# **A57 Link Roads Scheme DCO Application**

**Response on behalf of the Peak District  
National Park Authority to the Examining  
Authority's draft first written questions  
and requests for information (Issued on  
16 December 2021)**

**Produced by the Peak District National Park  
Authority (January 2022)**

**Fig 7.5 Indirect Representative Viewpoints within
Peak District National Park (PDNP)**

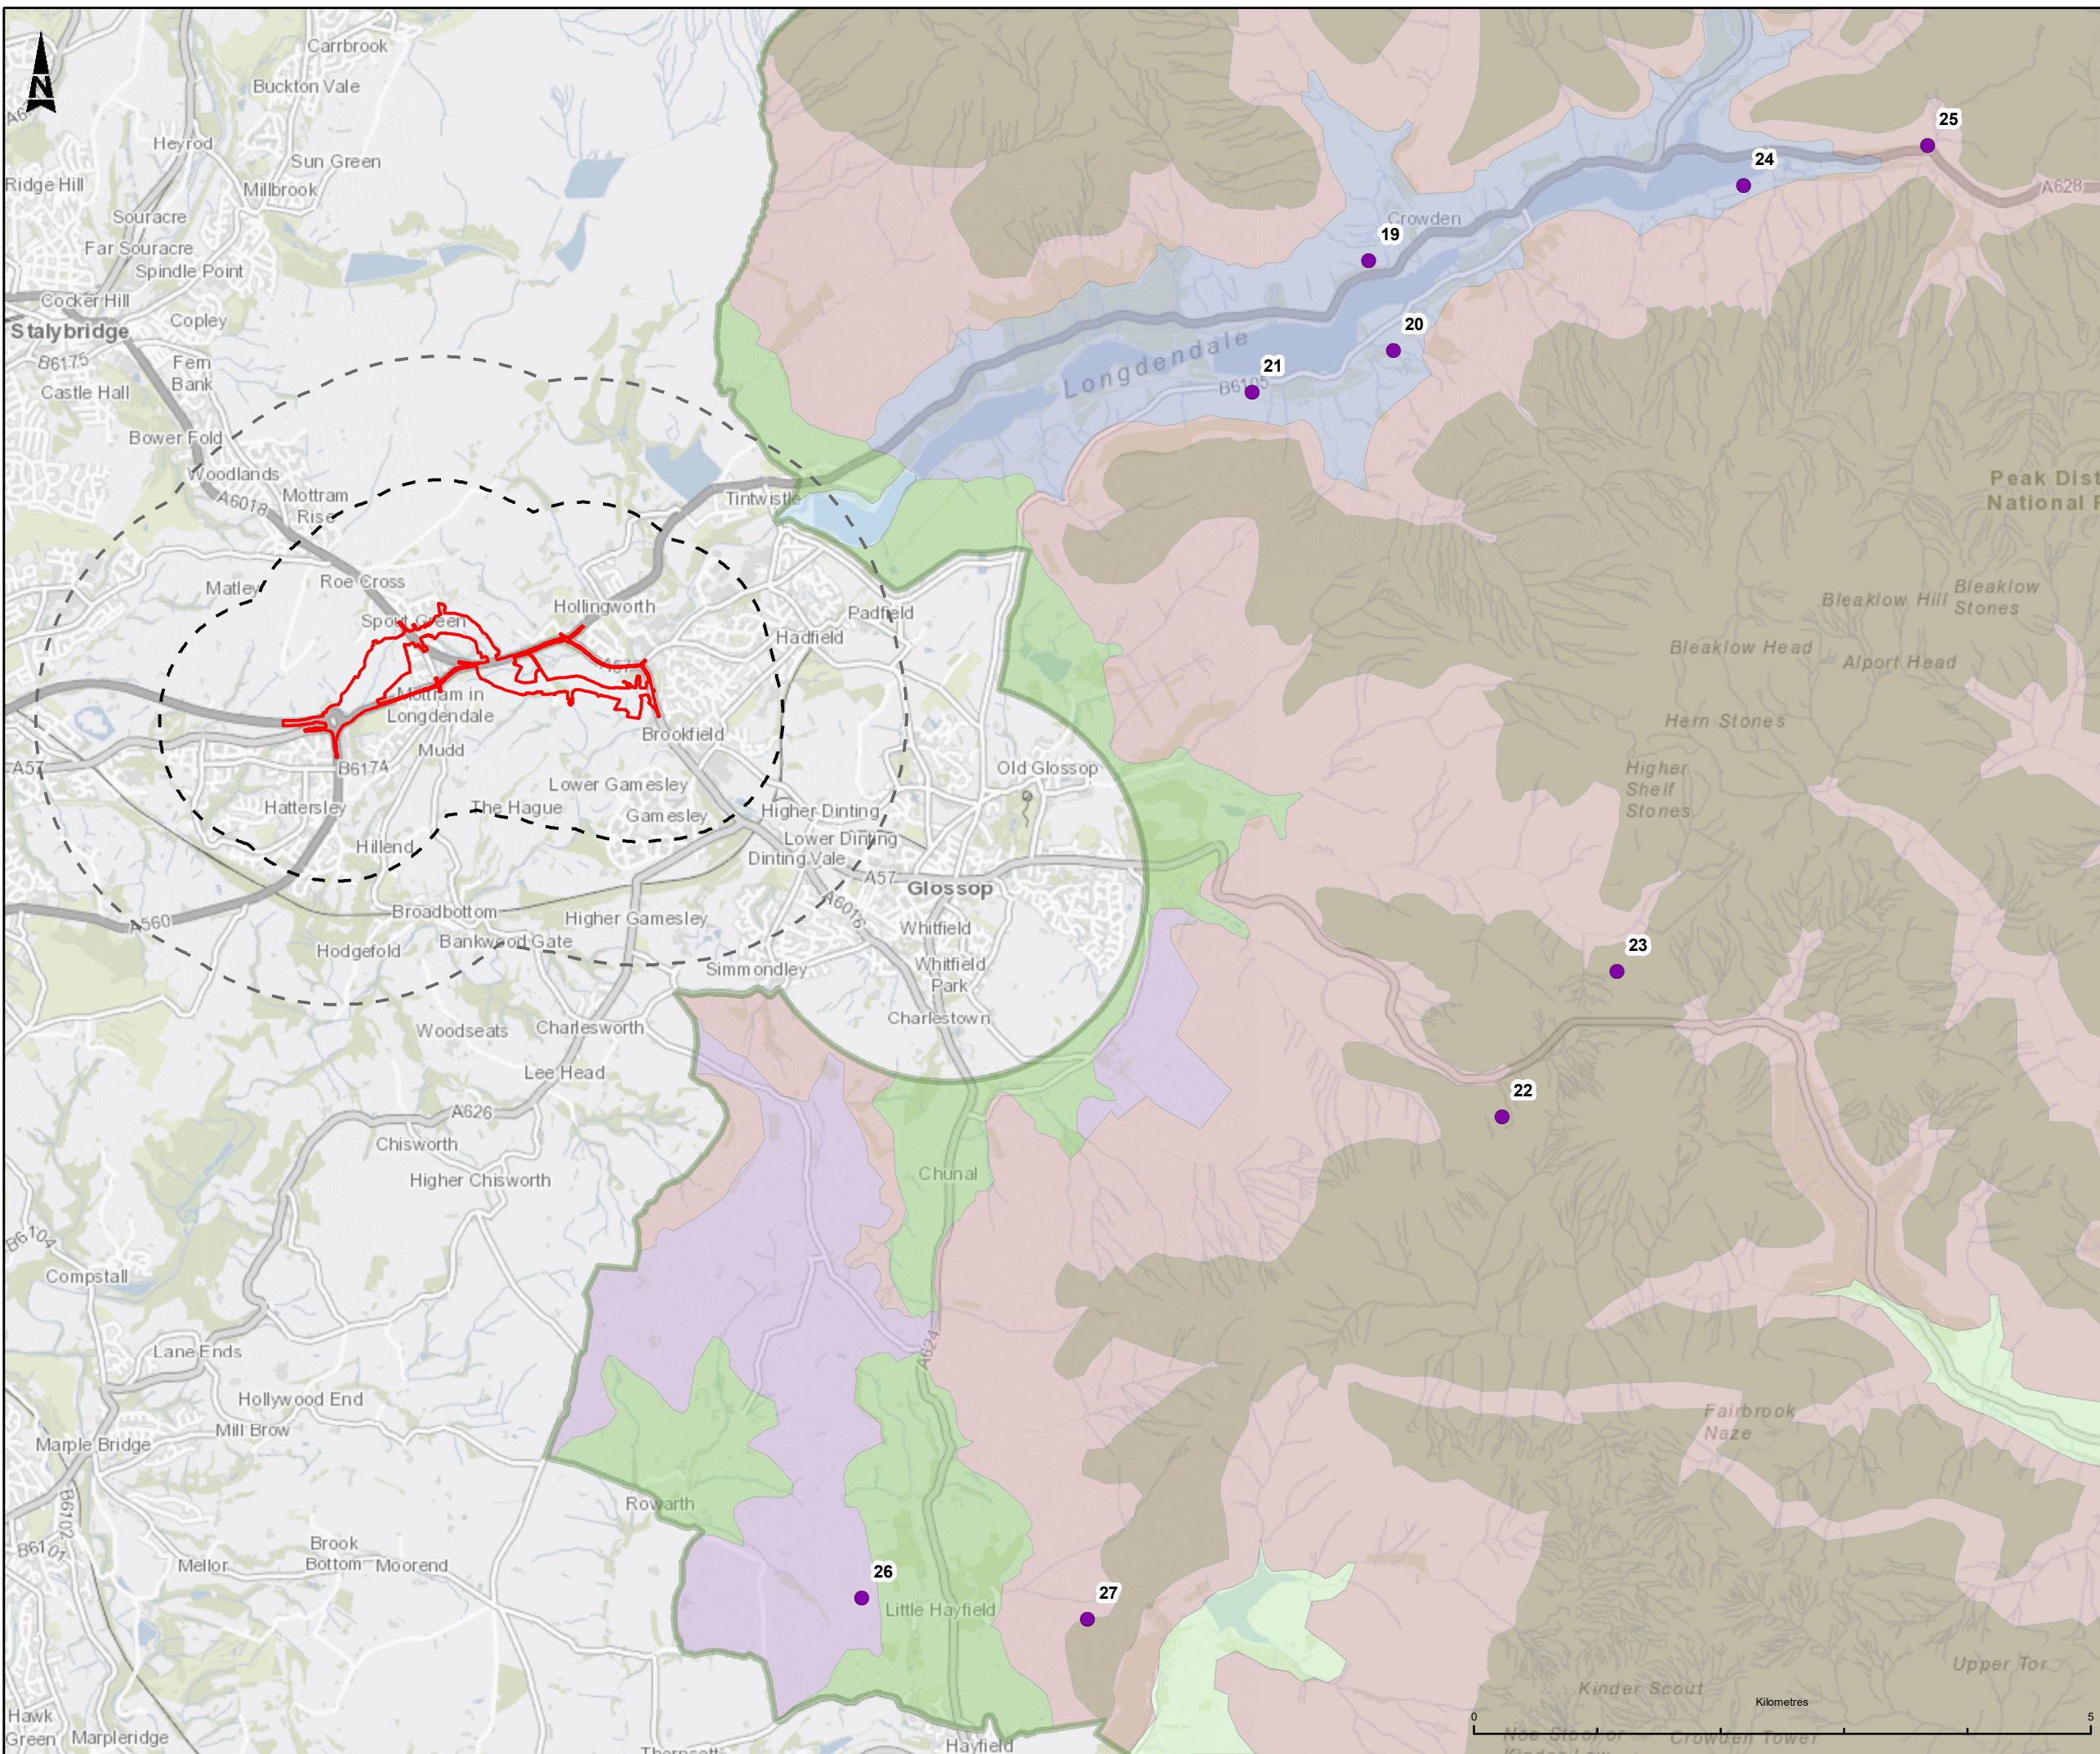
<b>6.</b>	<b>Landscape and visual</b>		
<b>Study area, baseline conditions and overall assessment methodology</b>			
5.3	Peak District National Park Authority	Peak District National Park Dark skies ES Chapter 7 [APP-063]	Paragraph 7.6.20 notes that consideration has been given to three areas within the Peak District National Park as “dark skies”, but these have been excluded from further assessment as the Proposed Development is unlikely to be visible from the sites.

<p>Is Peak District National Park Authority content that no further assessment is required?</p> <p>'Dark Skies' – indirect effects of lighting of the scheme may have adverse effects on the appreciation of dark skies from within the Park, so no, we do not believe that the assessment has given this issue adequate weight within the assessment.</p>

5.4	Local authorities Peak District National Park Authority	Viewpoints Night-time assessment ES Chapter 7 [APP-063]	<p>Paragraph 7.3.66 sets out viewpoints used to aid the assessment of night-time effects arising from operational lighting.</p> <p>Are the local authorities and Peak District National Park Authority content that the chosen viewpoints are representative?</p> <p>Viewpoints are acceptable</p>
